Site Development Plan_V1.pdf Markup Summary

SITE PLAN
SCALE: 1"=30'-0"

WIRENUT HOME SERVICES
6365 E PLATTE AVE.
COLORADO SPRINGS, CO 80915
EL PASO, COLORADO

① SITE PLAN
SCALE: 1"=30'-0"

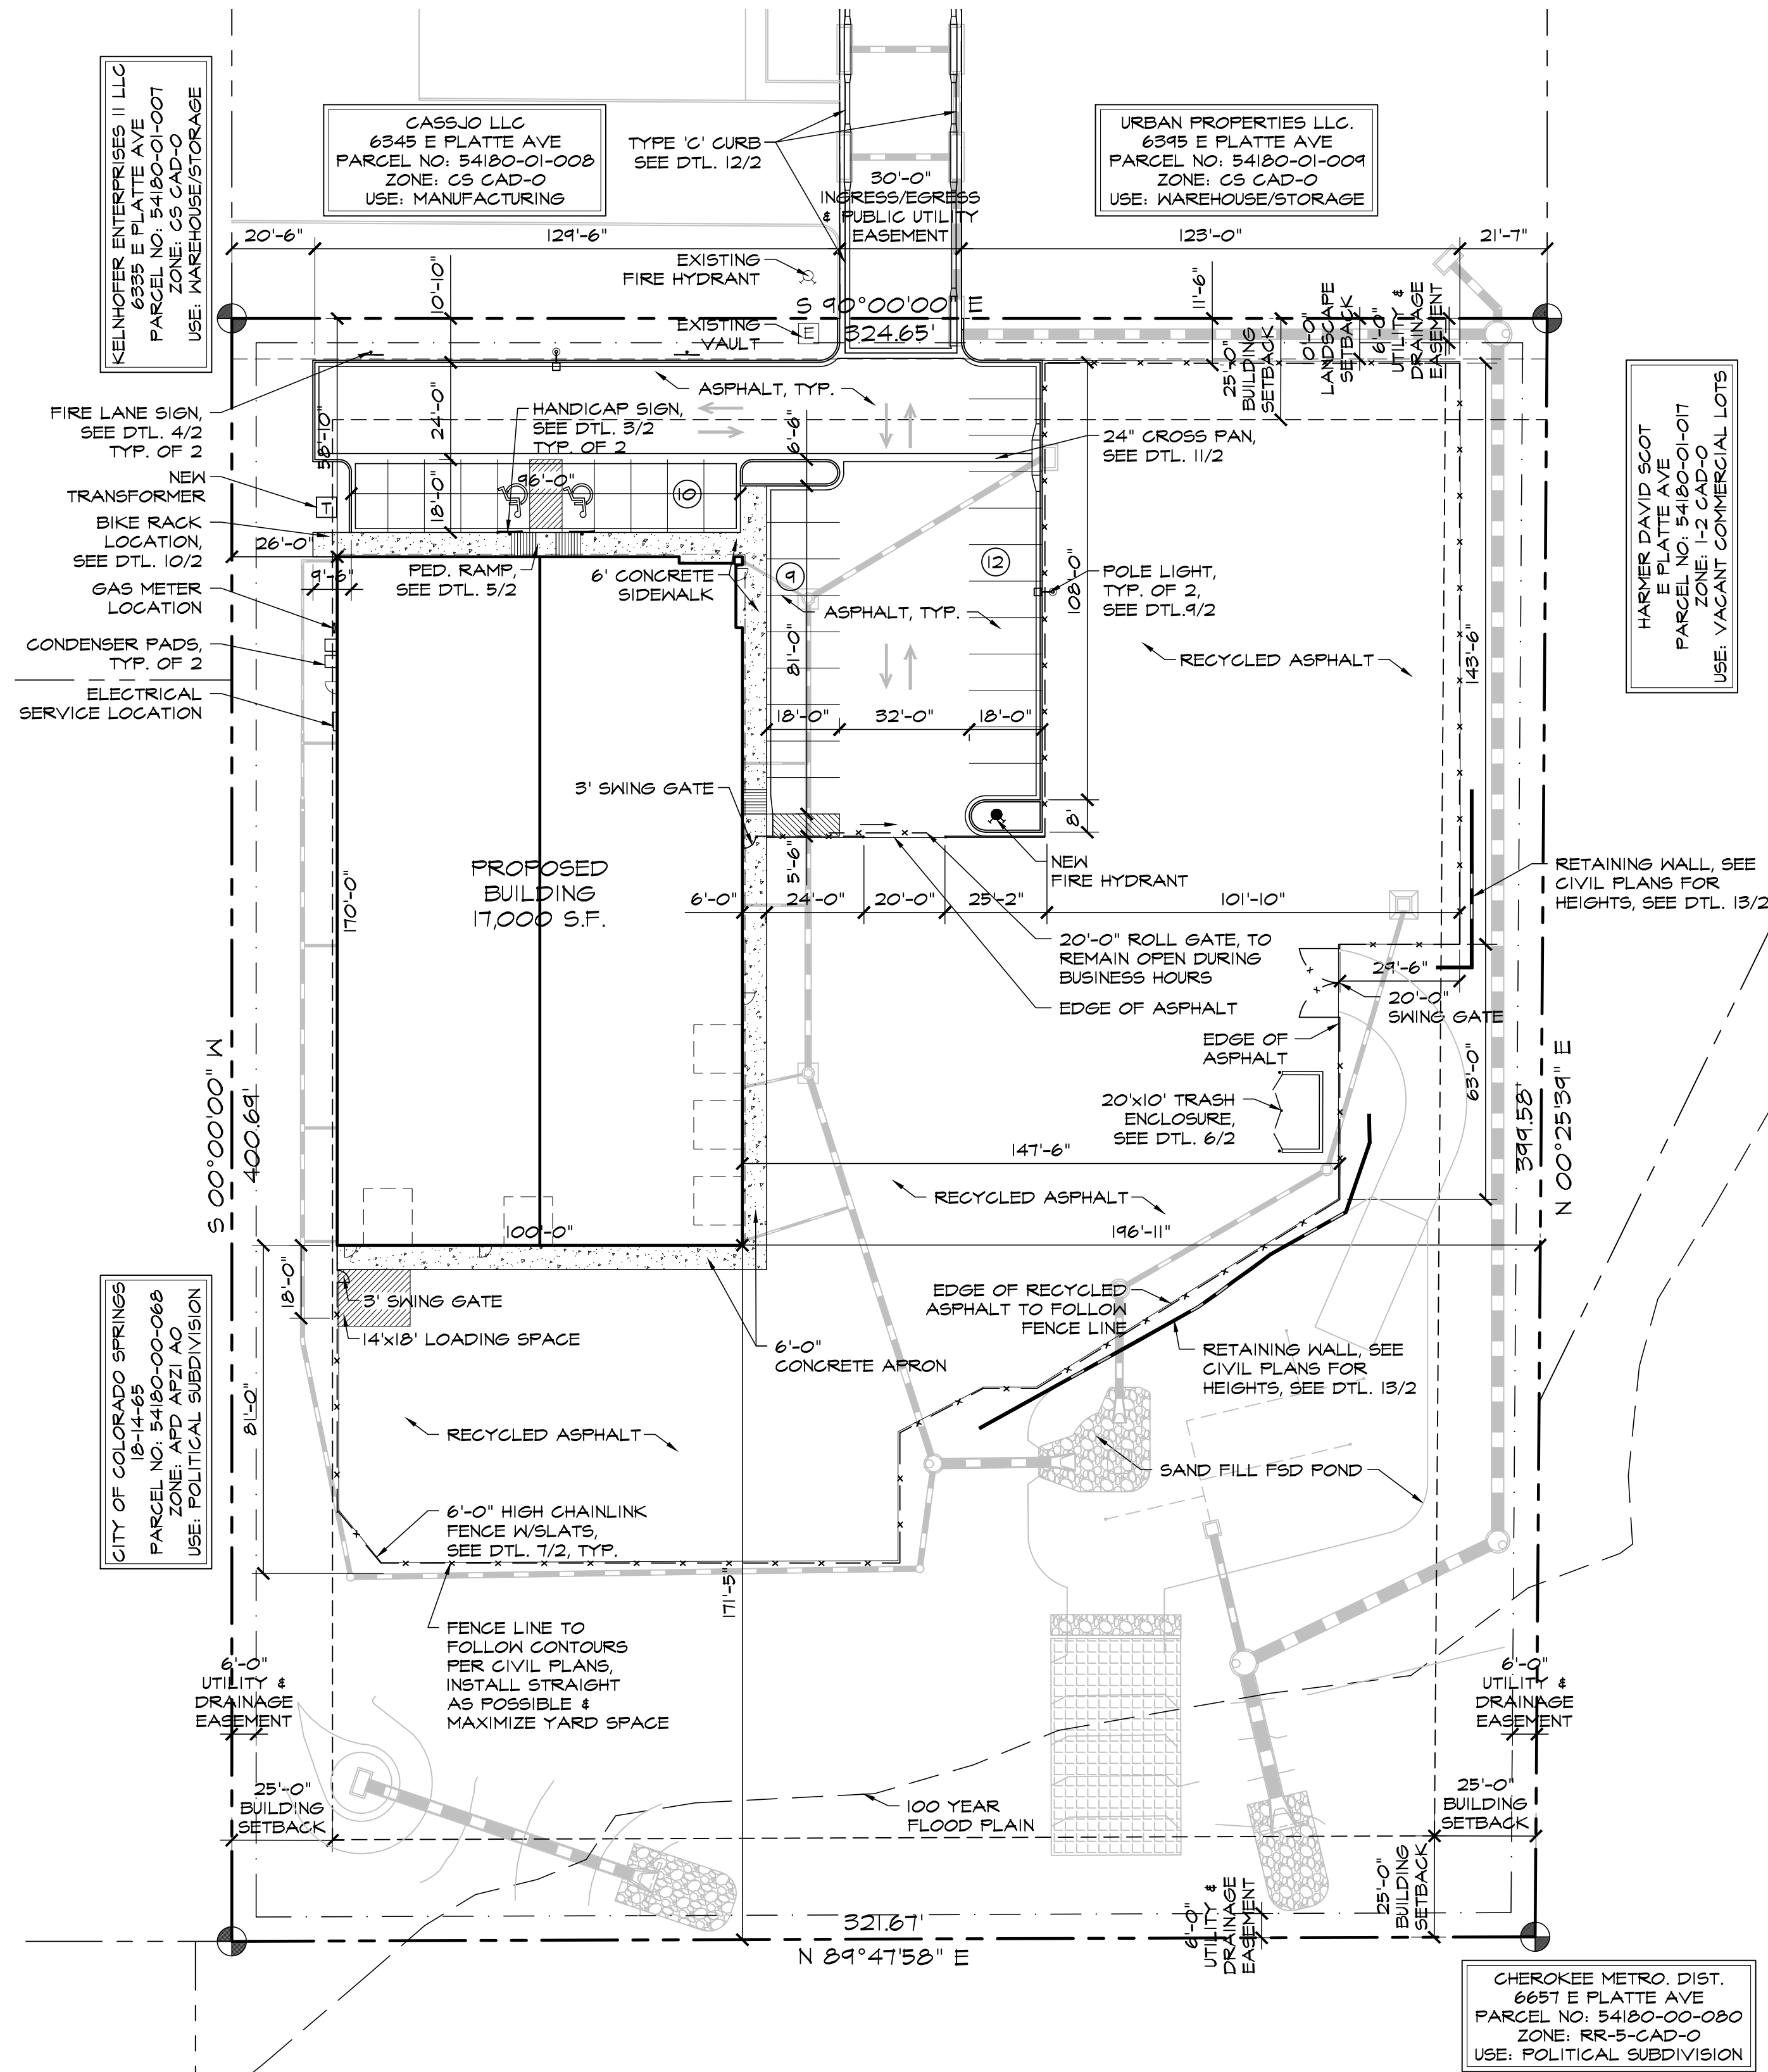
Revise to December 7, 2018 per FEMA FIRM map

identify that the floodplain area is no-build, no storage of materials

label the proposed curb/gutter throughout the plan

Please clarify the limits of the proposed recycled asphalt area. Does it only extend to the fenced area?

Is the recycled asphalt area to be used for outside storage? if so please identify the area for outside storage

Provide breakdown of lot coverage calculaion

Is the building setback 20' or 26'?

Building setback? 26' or 20'?

Per SDP checklist show locations of all sidewalks, trails, fences and walls, retaining walls, or berms

Per SDP checklist show the layout and location of all off-street parking, loading and other vehicular use areas, unless otherwise depicted in detail on a separate parking plan. If depicted on a separate parking plan then depiction of the parking areas are required.

Inconsistent to the count of 62, please clarify

Application form states a different SF, please clarify

Per SDP Checklist, show all location of all existing and proposed utility lines and associated infrastructure

Min. setback for CS zone is 25'

Add PCD File No. PPR-2234.
